**Determination of Modification Request
86-96 and 100 Mount Street, North Sydney (MP 08_0241 MOD 5)**

Plan - B4 Level

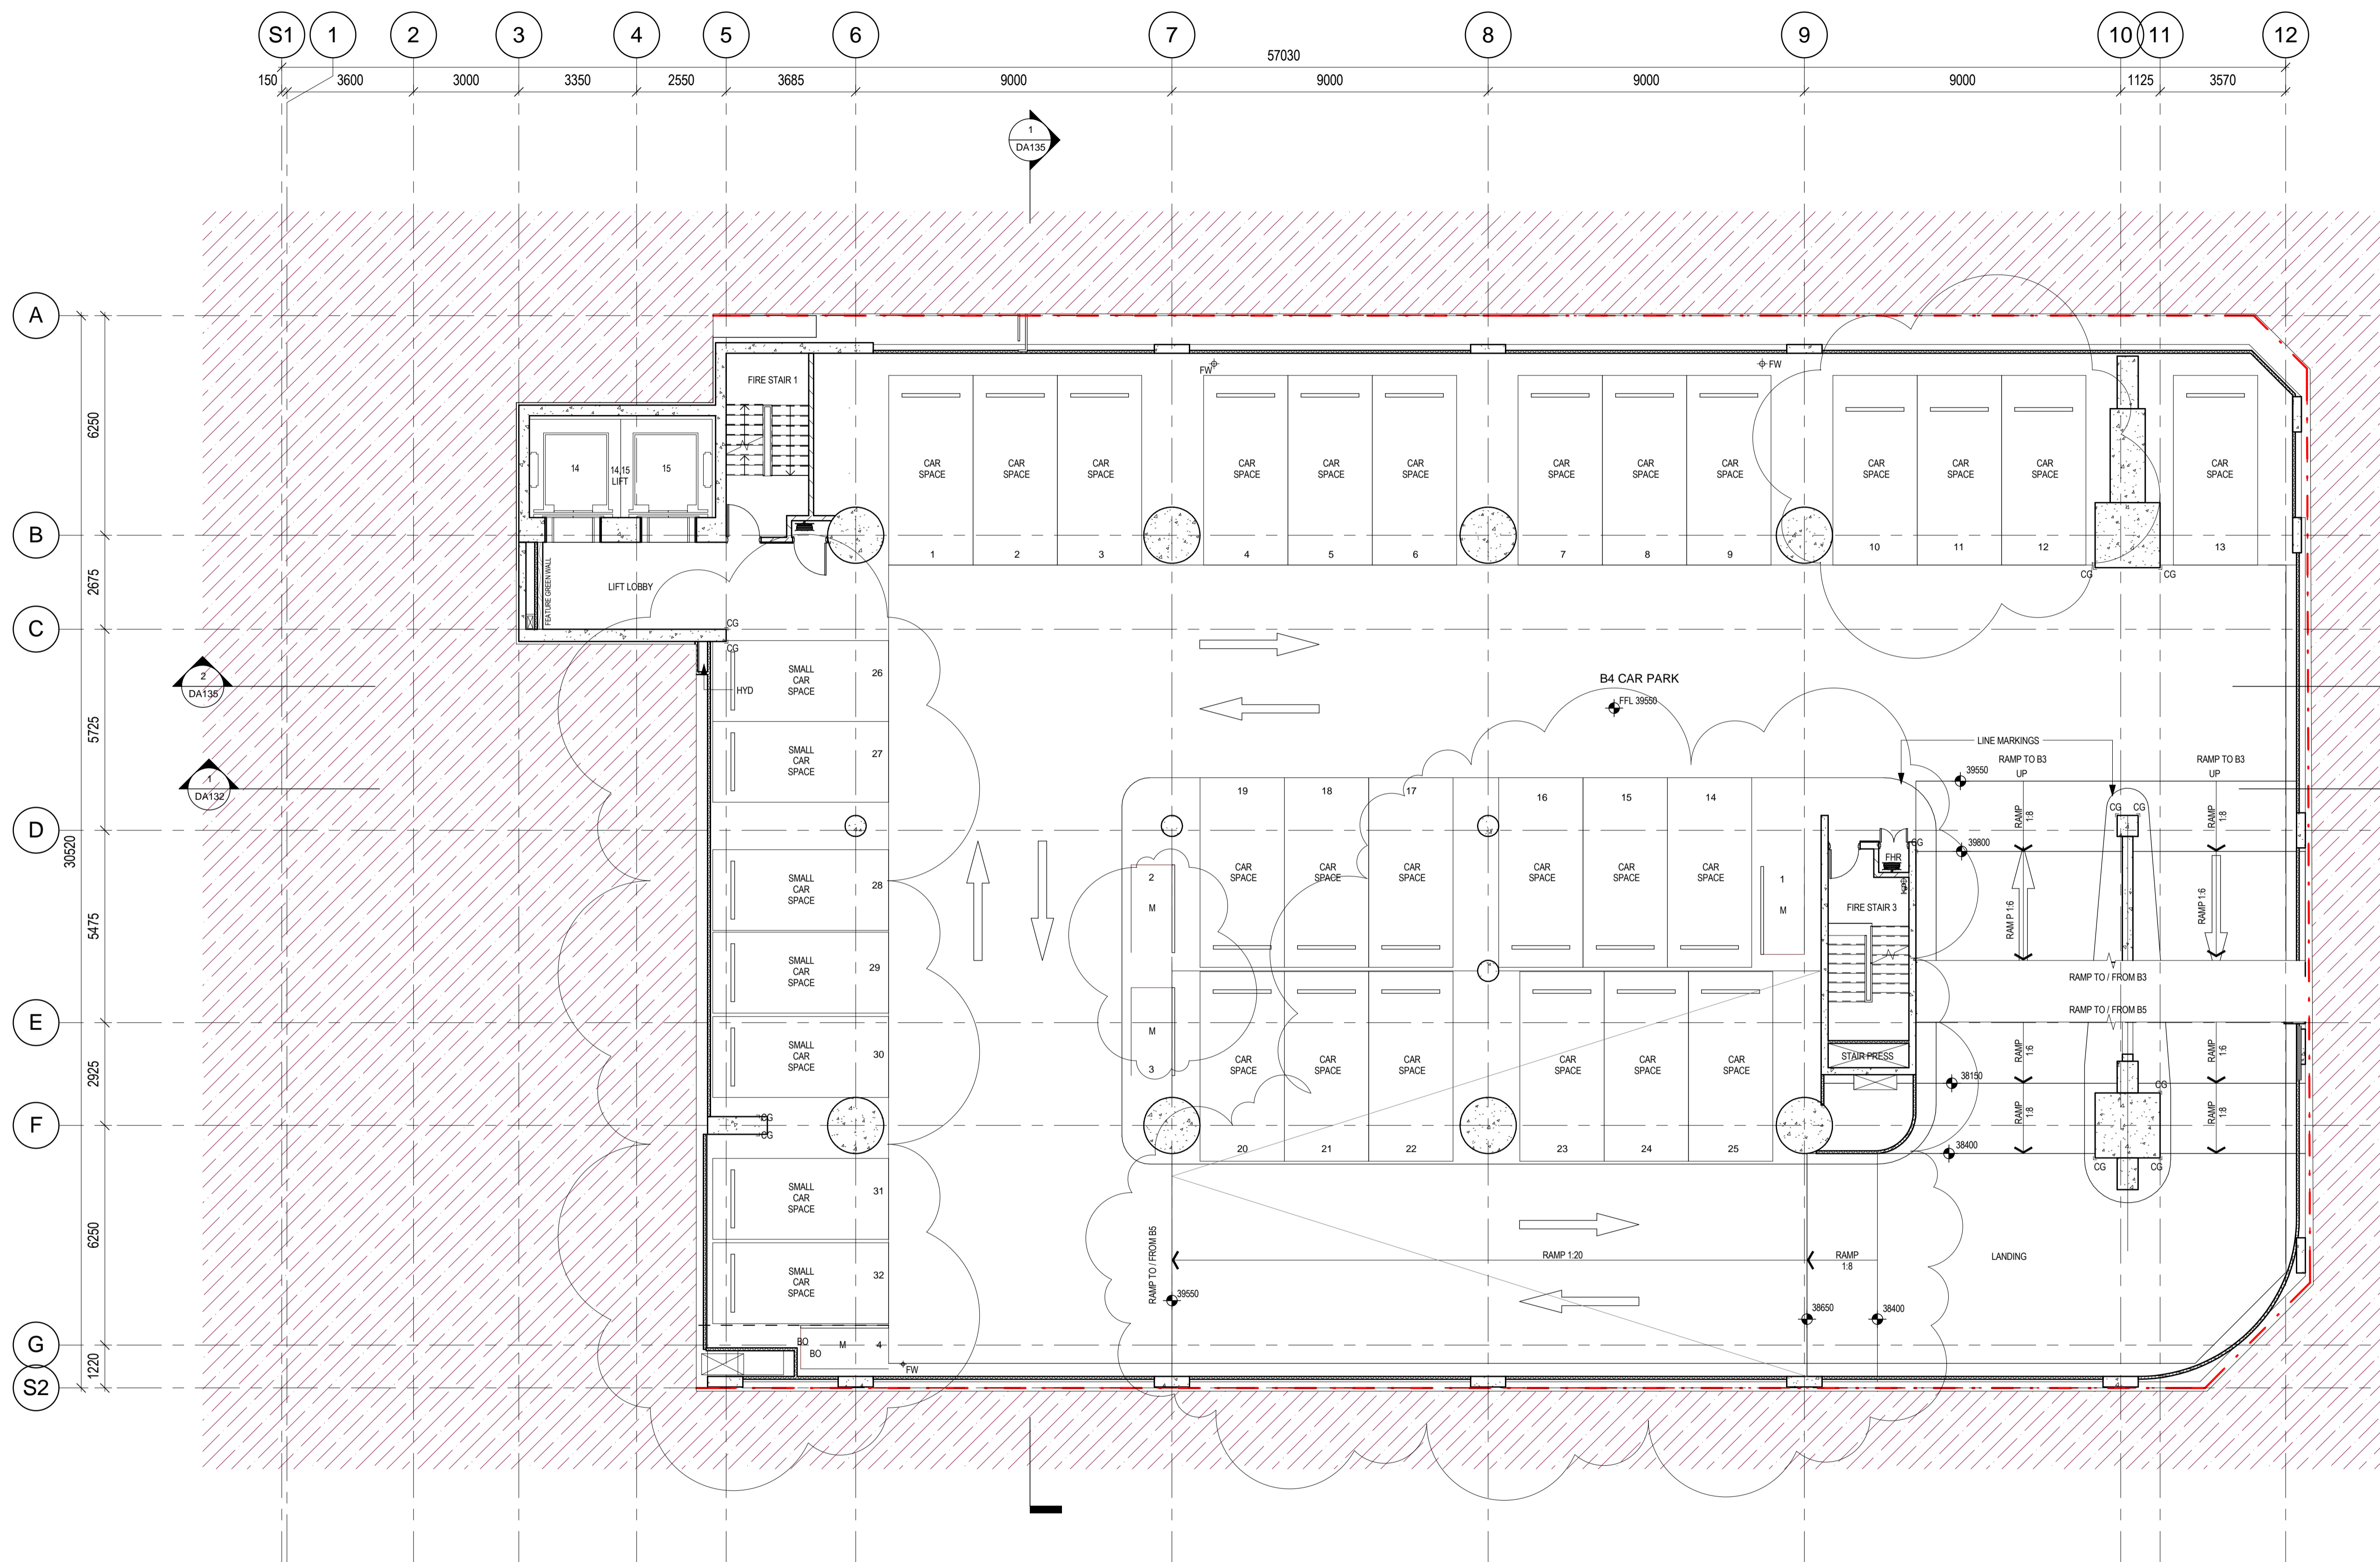
- there is adequate space within the development to provide the 330 bicycle parking spaces required under the original approval;
- an additional two car parking spaces is adequate to accommodate the increase in gross floor area. The amended number of car, motorcycle and motorbike courier parking spaces is in keeping with Council's controls;
